Your ref:	Internal Alterations to Parti...	<b>Please reply to:</b>	<b>Fraser Fikrie</b>
Our ref:	21/05122/LBC	Tel No:	0753424 7967
		Fee Queries:	0207 641 6500;
		Email:	planningreception@westminster.gov.uk;
Ms Sam Akbari Retro Design House 197 Manor Grove Richmond TW9 4QJ London		<b>Incomplete Applications</b> Development Planning City of Westminster PO Box 732 Redhill, RH1 9FL	
		2 August 2021

**Address: Flat 144, Dorset House, Gloucester Place, London, NW1 5AQ,**

**Proposal: Alterations to the living/bedroom non-load bearing wall to allow for the relocating of the kitchen, providing modern, open plan living within the existing grid system of the apartment.**

21-109- LP 10

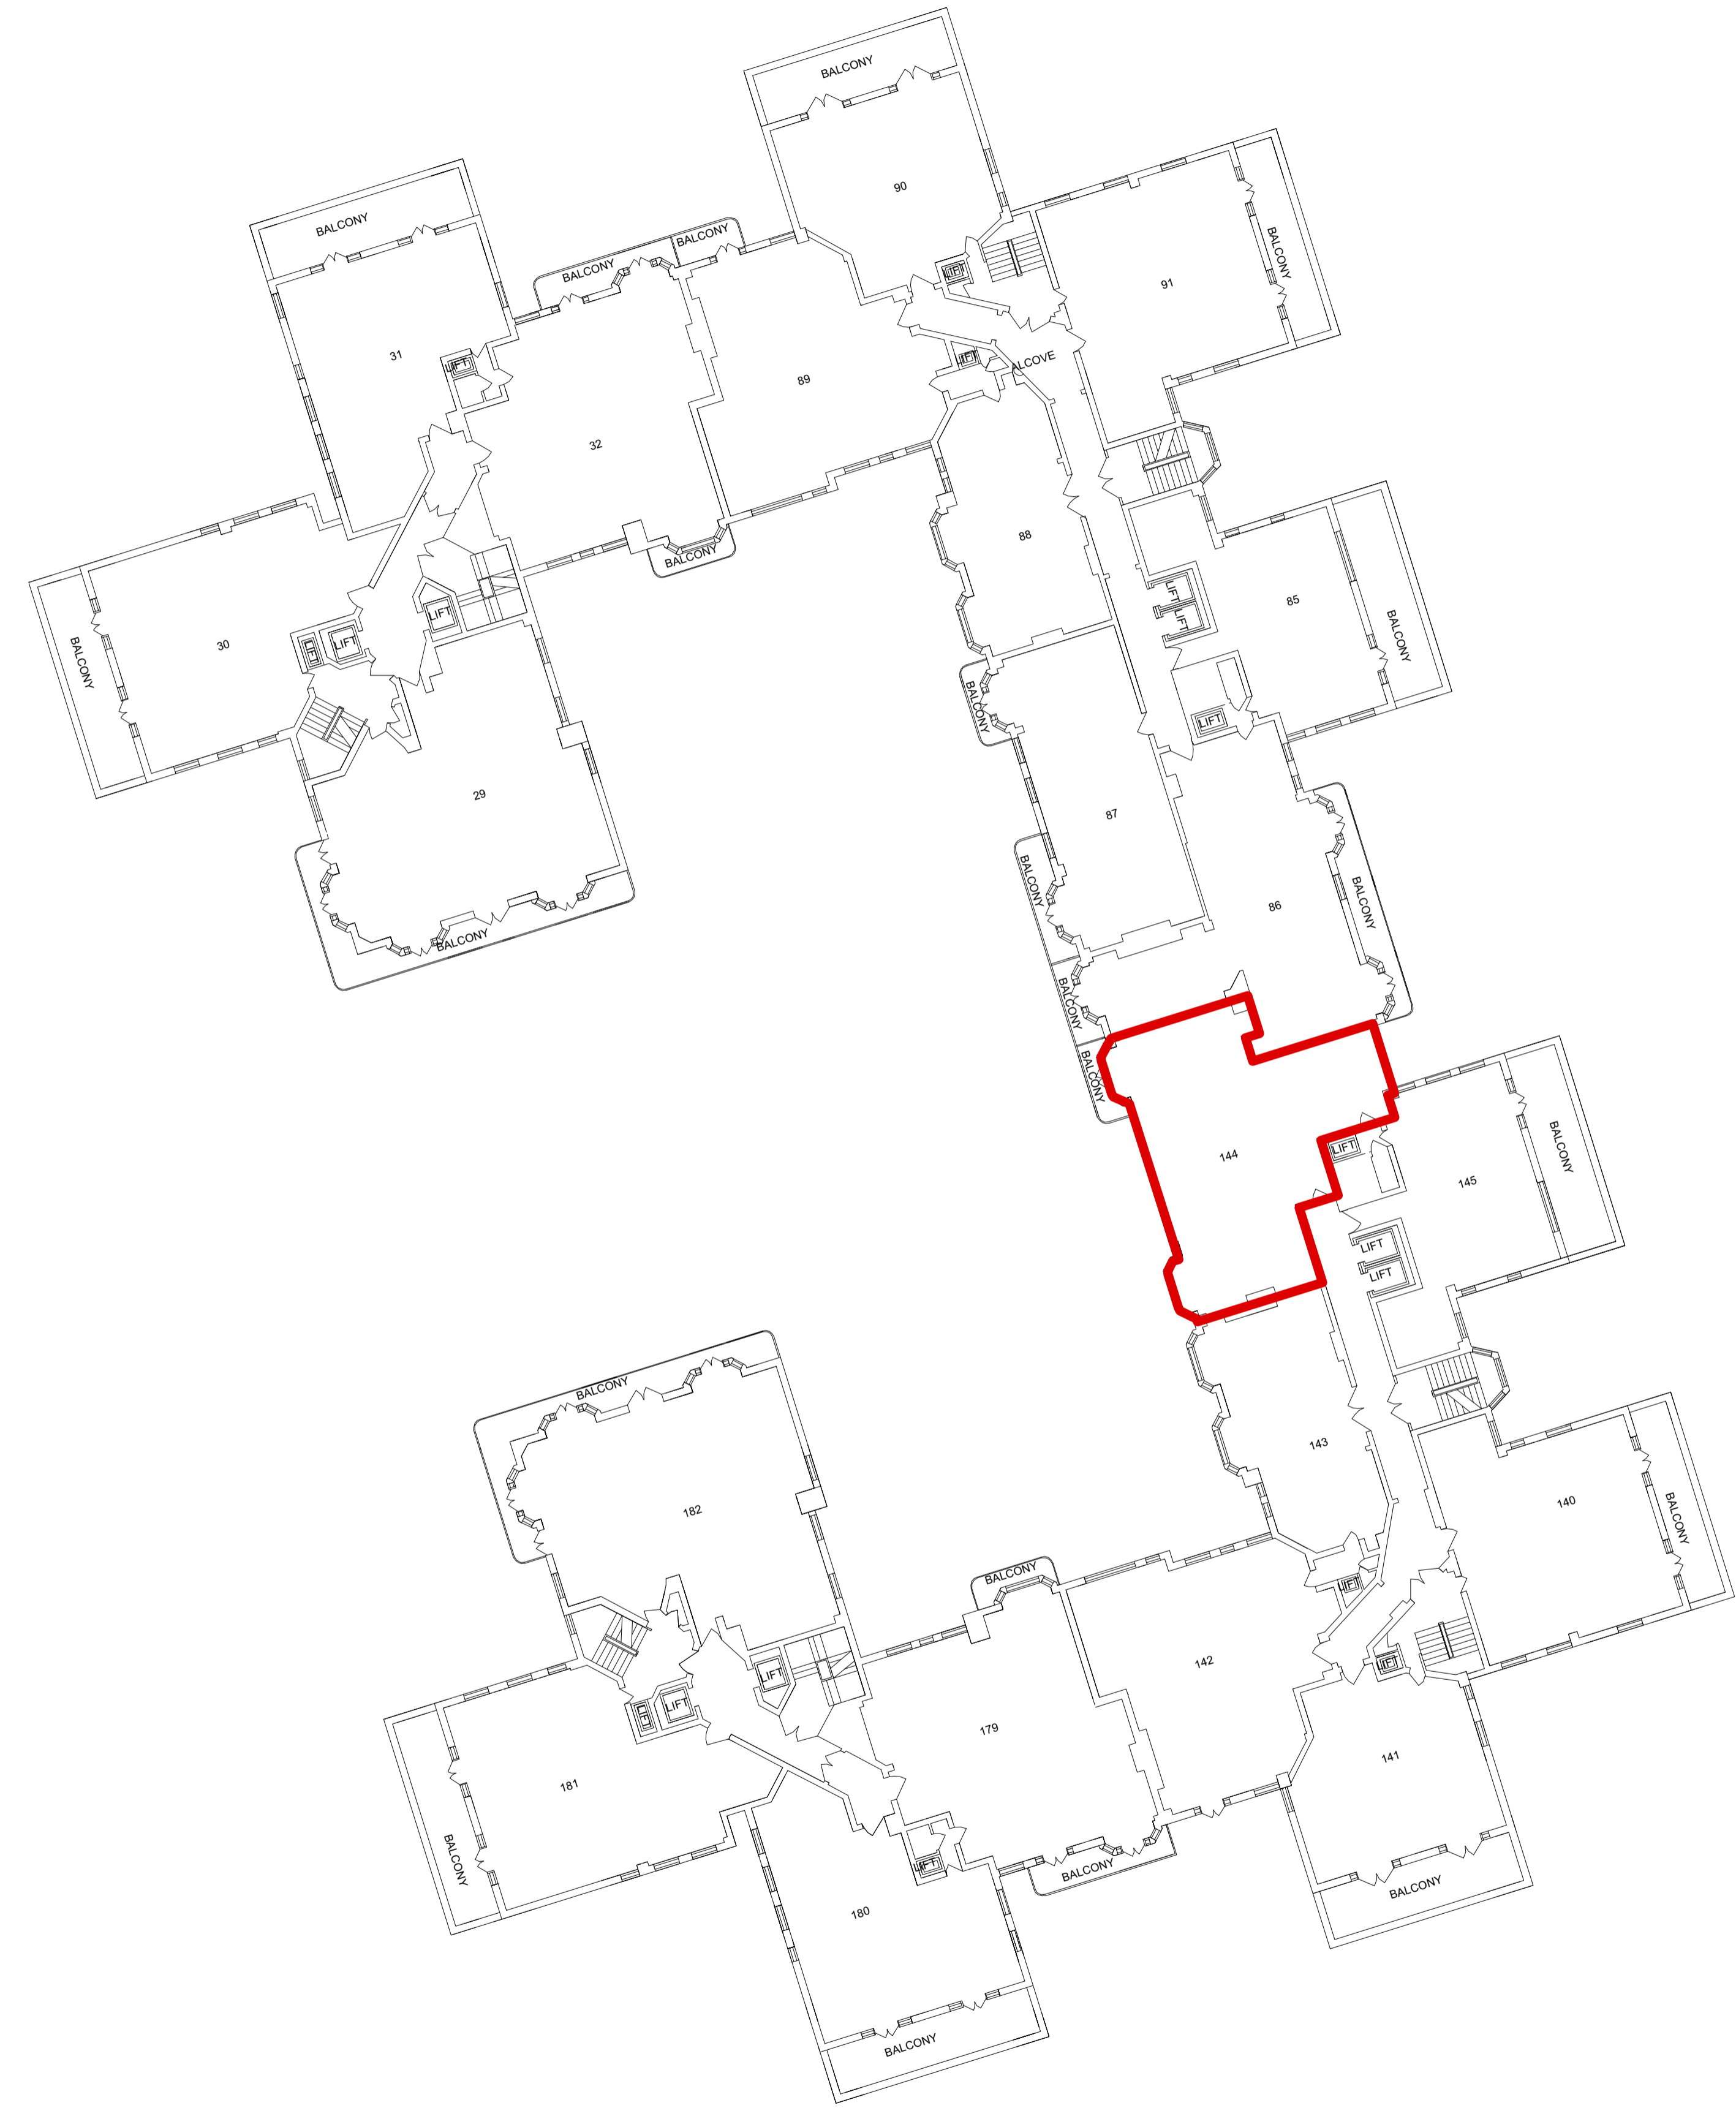
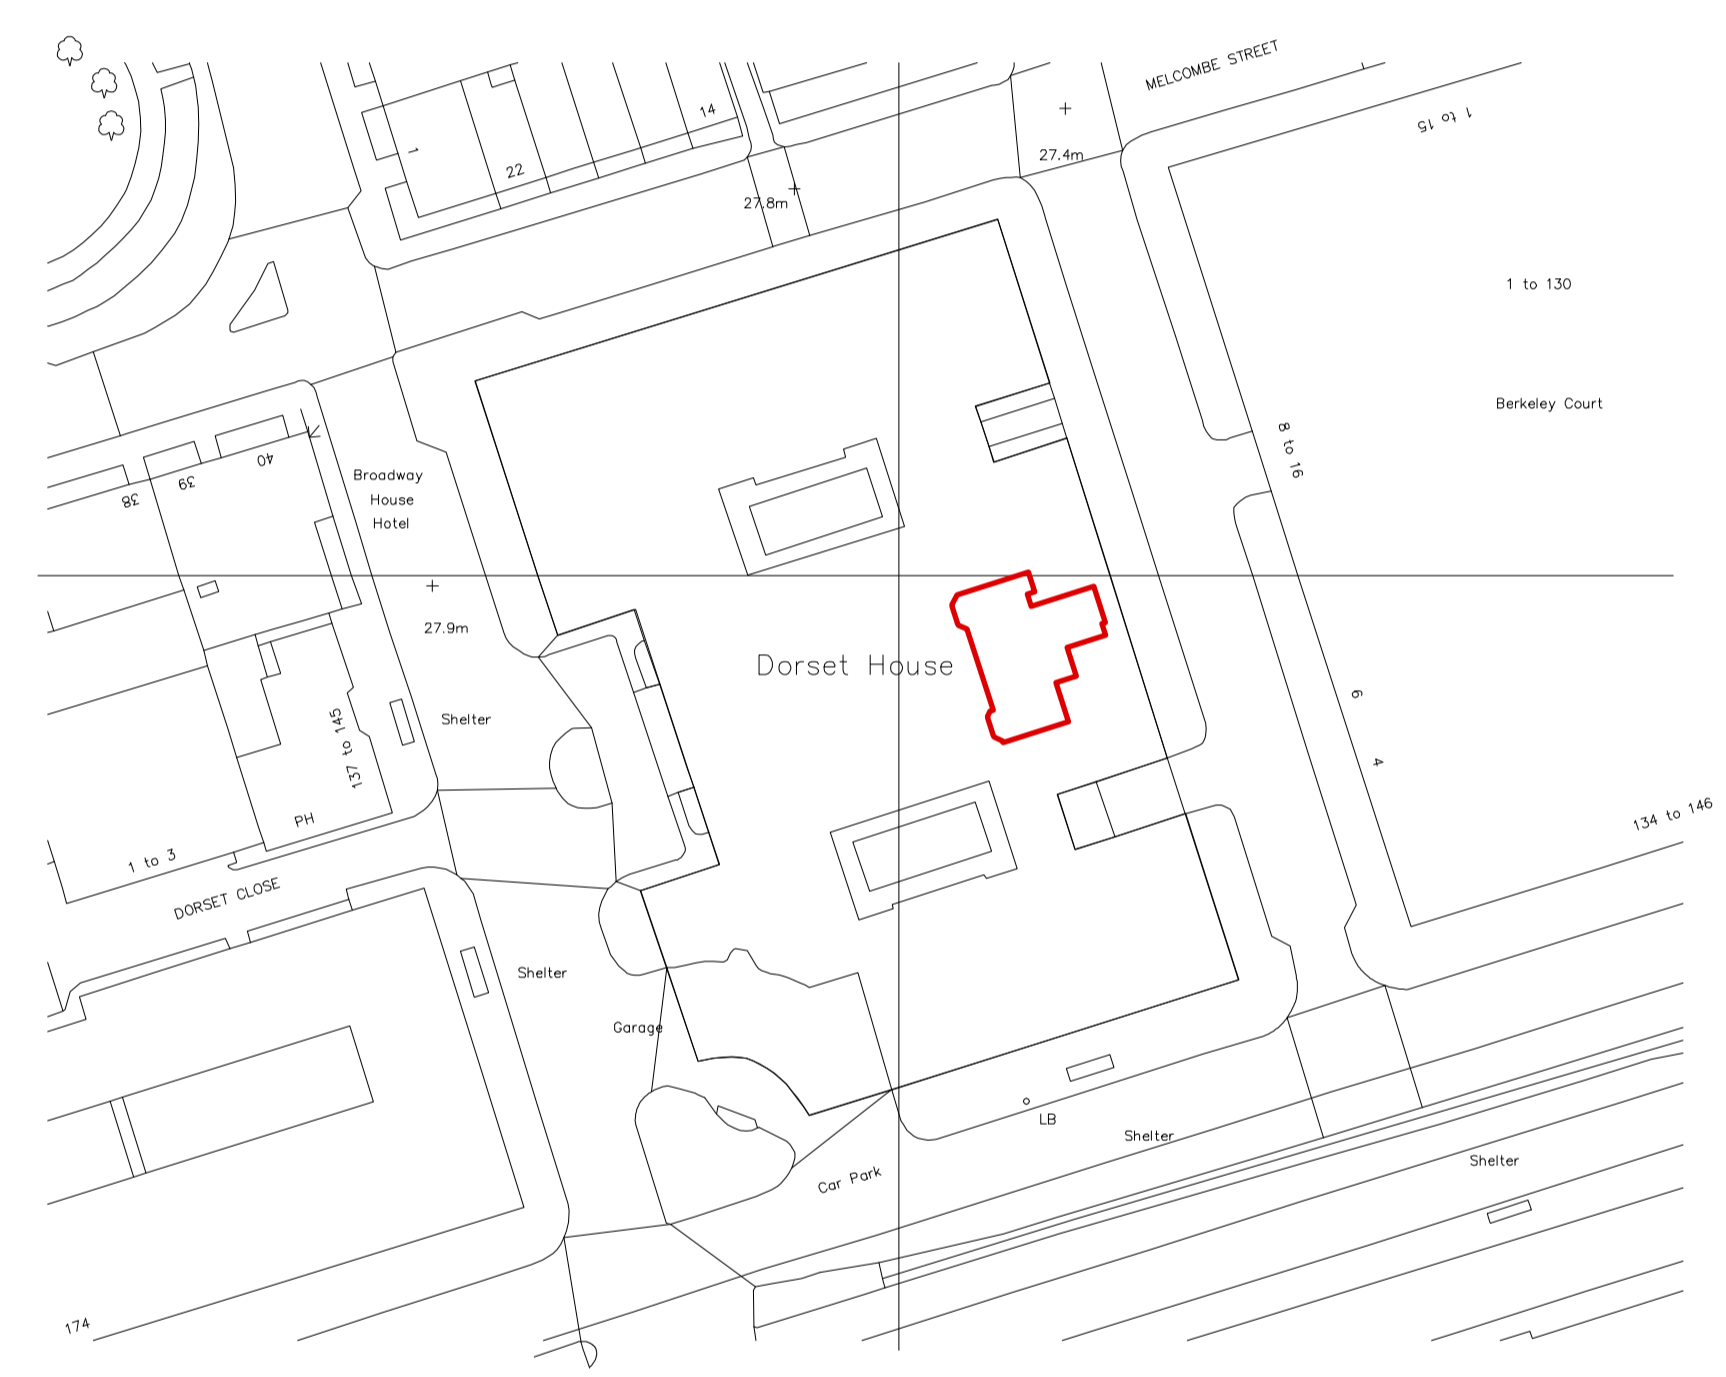
- 1 No location plan was submitted with your application. Please provide a location plan based on an up-to-date map at a scale of 1:1250 which shows the direction of north and clearly shows the site outlined in red and any other land in the same ownership outlined in blue.

Drawing number: 21-109-LP- 10 is block plan not a location plan. Please provide a location plan as per the above request.
